Phase II office Expansion

RE: Maine Orthopaedic Center, 1601 Congress Street
CBL: 220-C-001

**RE: Maine Orthopaedic Center, 1601 Congress Street
Response to Engineering Review**

7 DRIP STRIP AND FOUNDATION UNDERDRAIN  
NOT TO SCALE

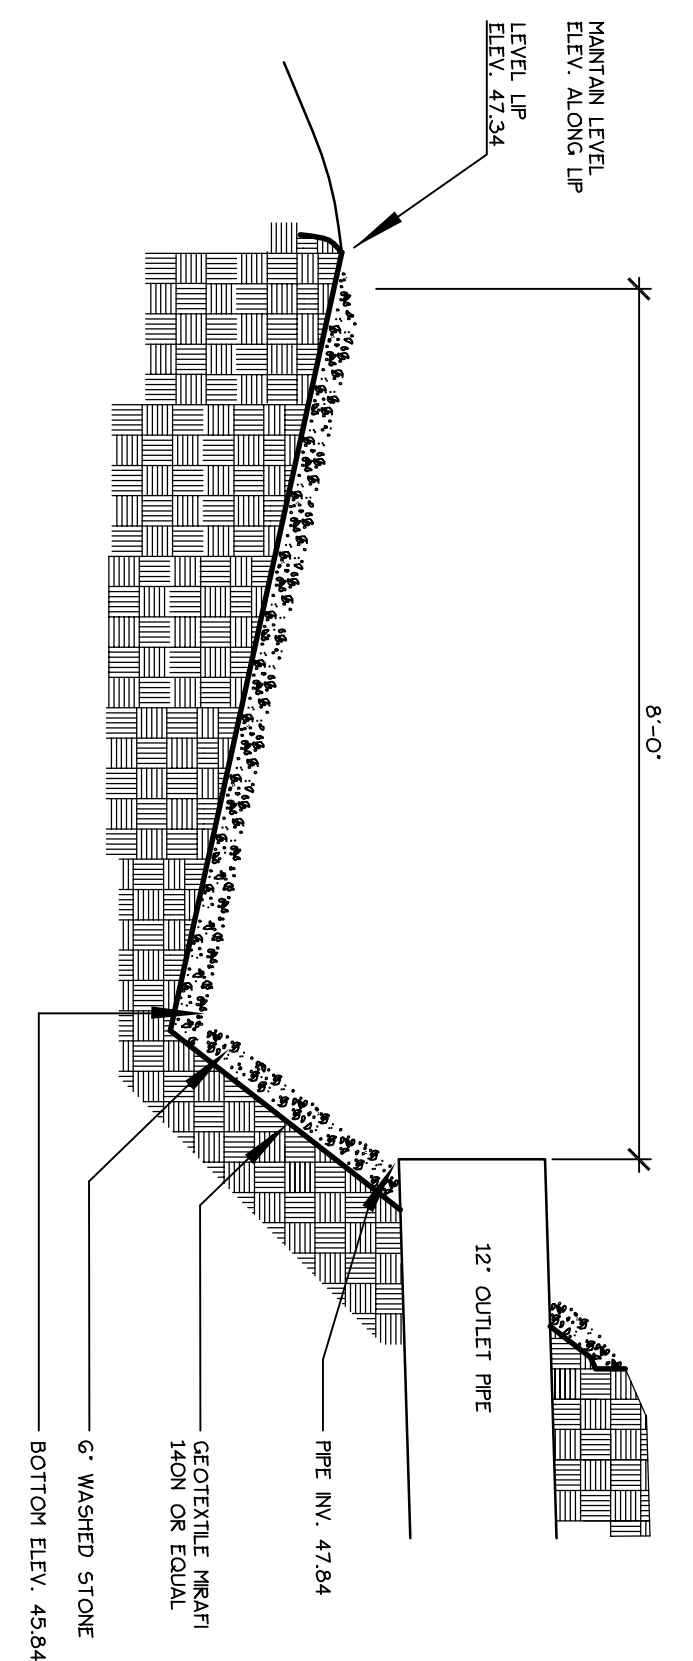
D. Roof Drainage. Roof lines have been added to Sheet 2, Site Plan. Water within the flat roof on the eastern side of the addition will be exiting the building through a roof drain into the proposed catchbasin to the east of the addition. The portions of the sloped roof which do not drain onto the flat roof will drain from the eave onto a drip strip and into a foundation drain system. The foundation drain will connect into the existing foundation drain system. A detail for the drip strip and foundation drain have been added to Sheet 3.

8 LEVEL LIP SPREADER  
NOT TO SCALE

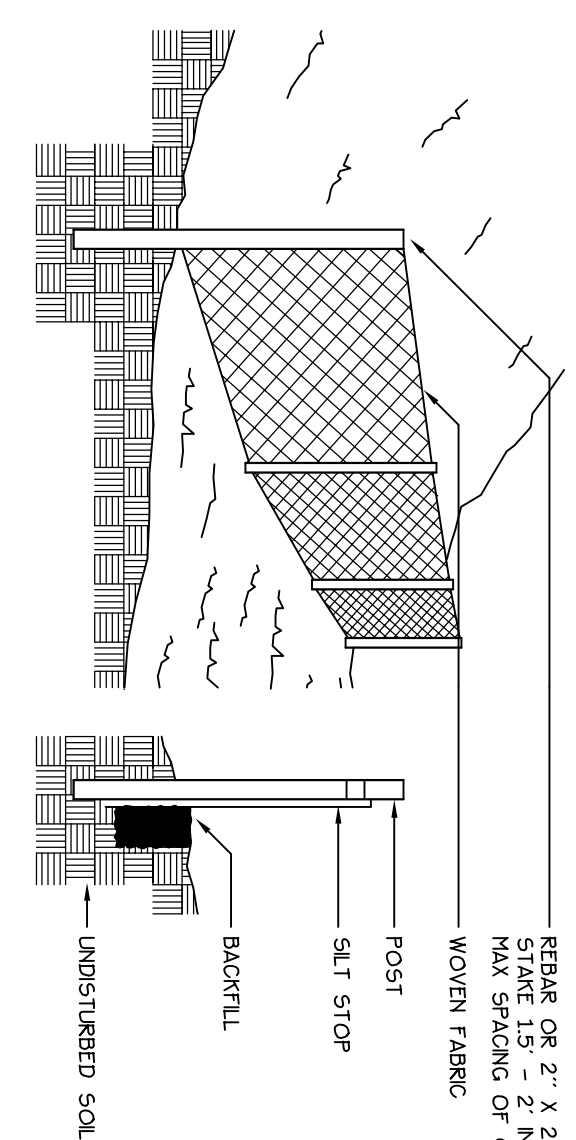
In accordance with Chapter 500, State Stormwater Law, level spreaders are sized at 0.25 c.f.s. per linear foot for a 10-year storm. Your proposed level spreader has a drainage area of 9,600 s.f. and a peak 10-year storm (4.7 inches of rain) flow of 1.58 c.f.s. This requires just over six feet of level spreader. Therefore, we recommend that you design the level spreader eight-feet long.

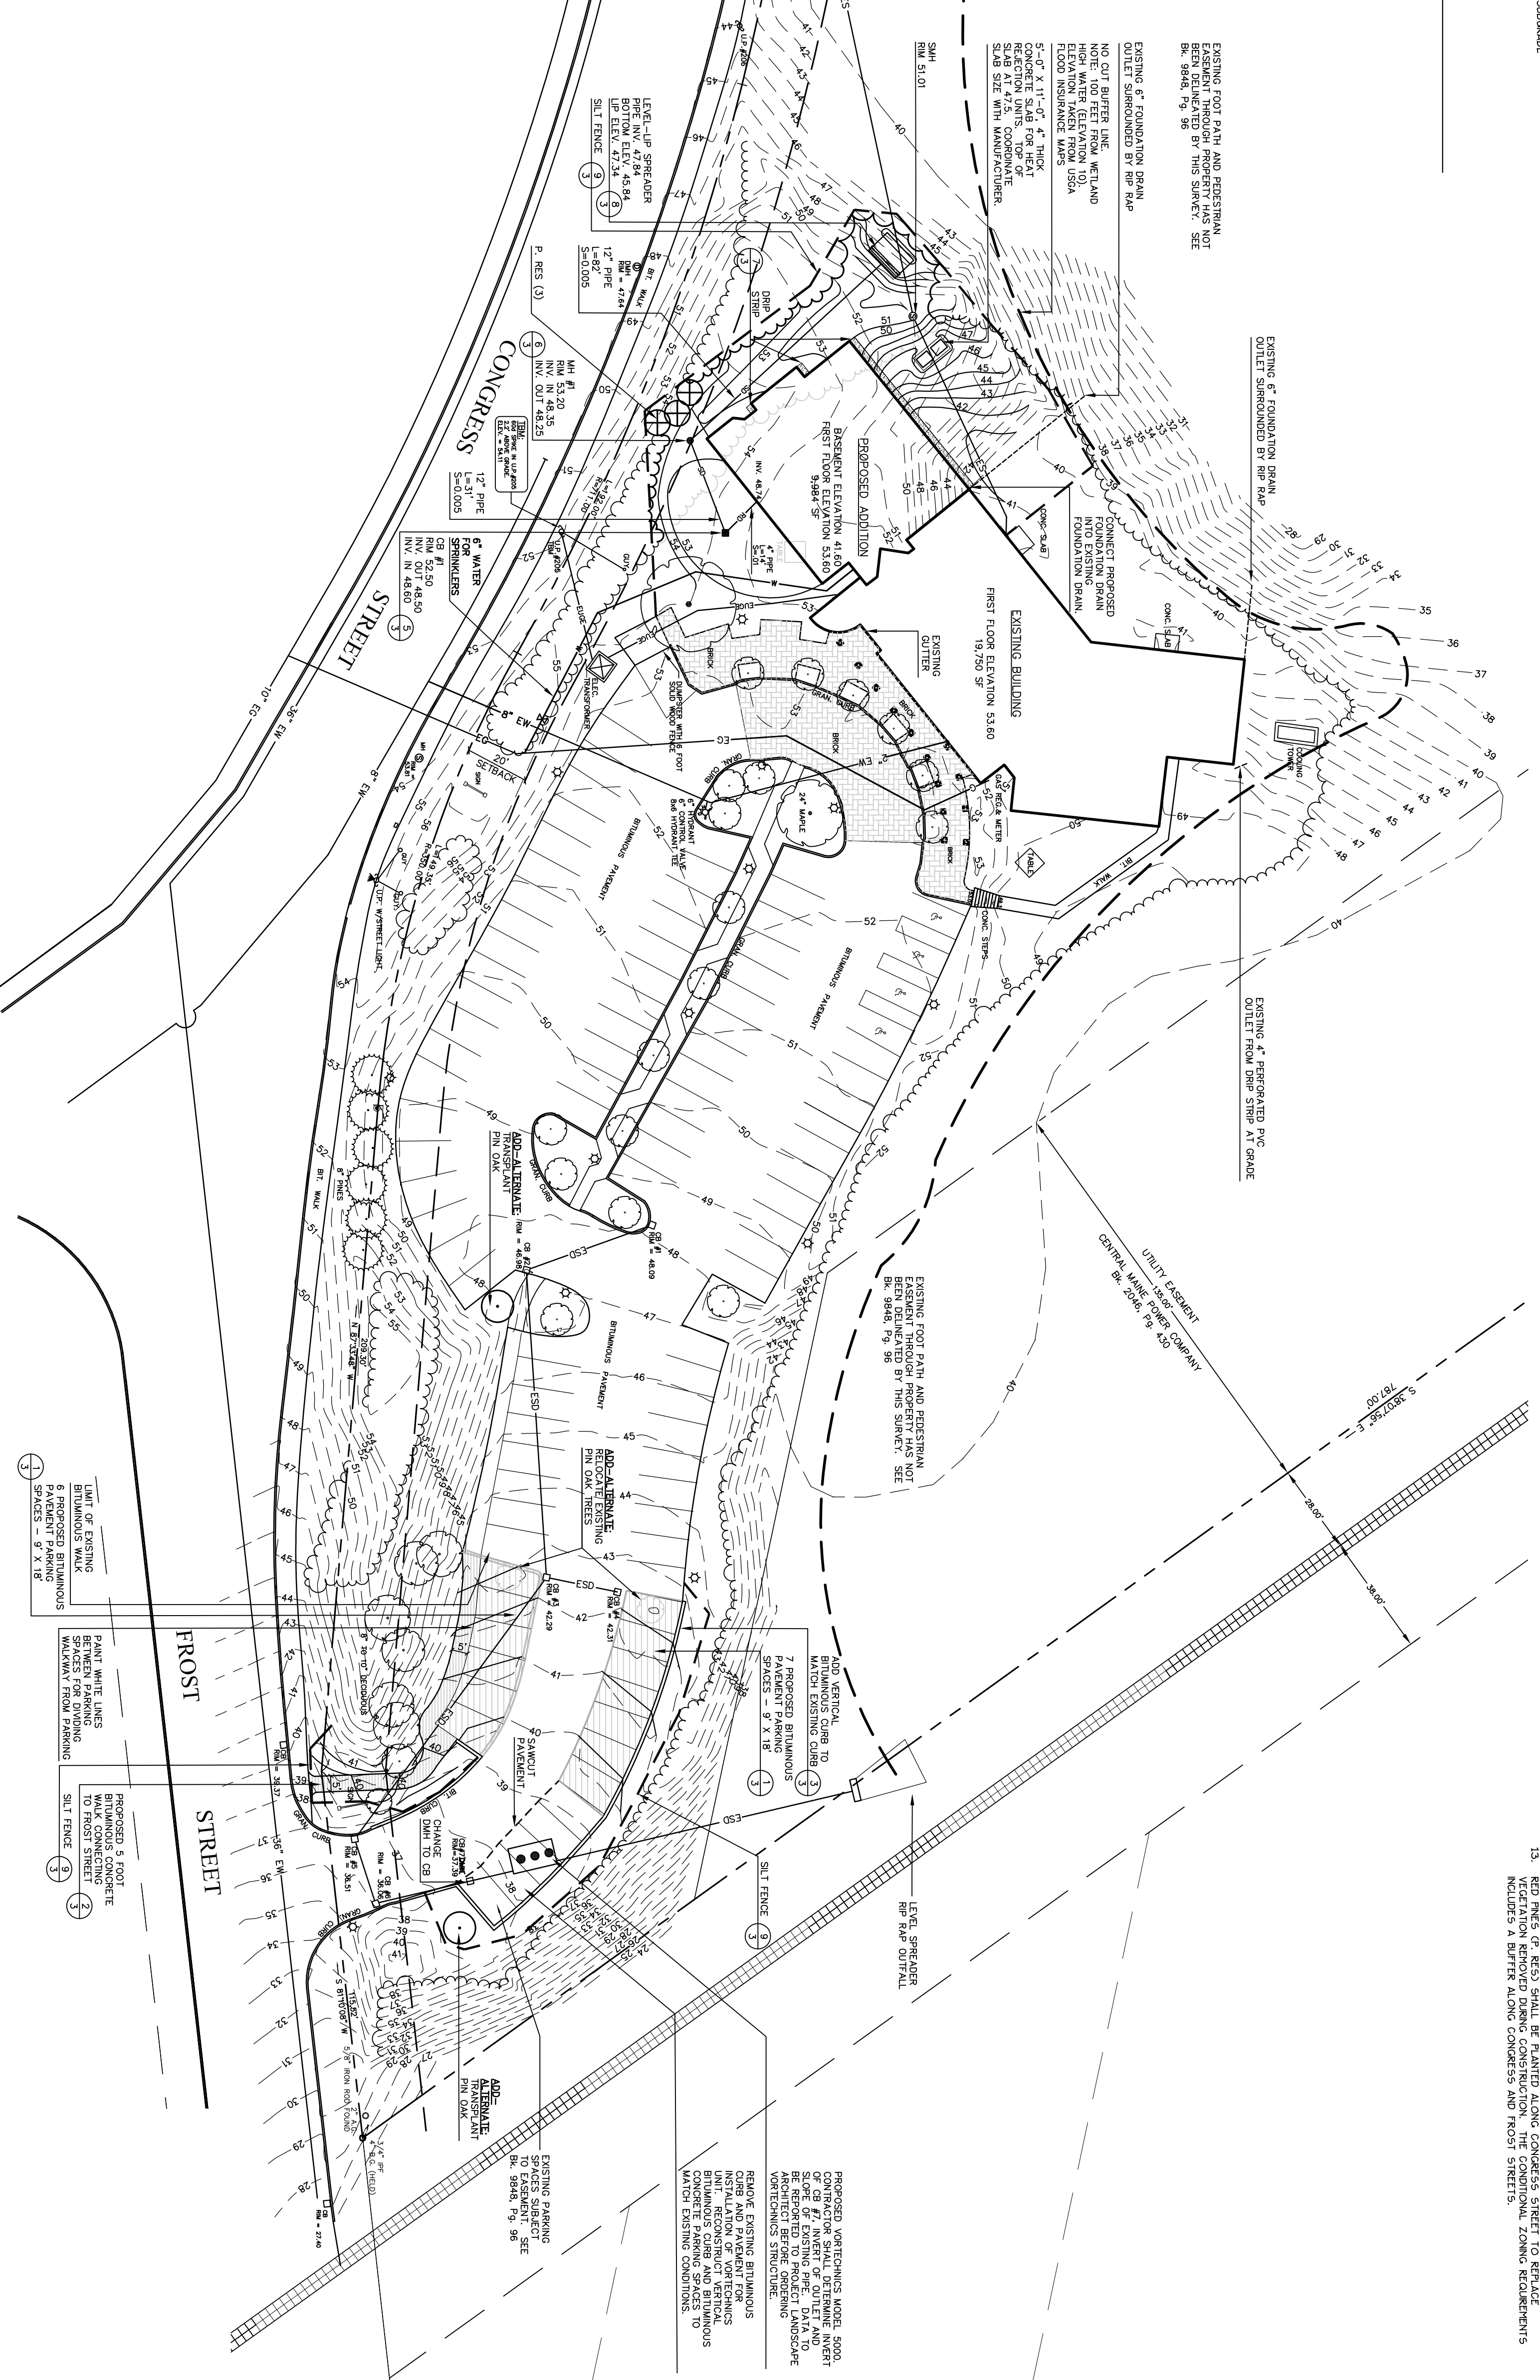
B. Water Service. An additional 6" water line for the sprinkler system has been added to the plan, tapped from the 8" line. The route of this line is within the lawn area so as not to disturb existing pavement or plantings. The domestic water service for the building addition will connect internally through the existing building. Please see Sheet 2 for water line location.

A. Additional Silt Fence. Silt fence has been added to the area of the site where bituminous curbing has been added to the plan. This silt fence also accounts for the addition of the Vortech unit. Please see Sheet 2 for silt fence location.
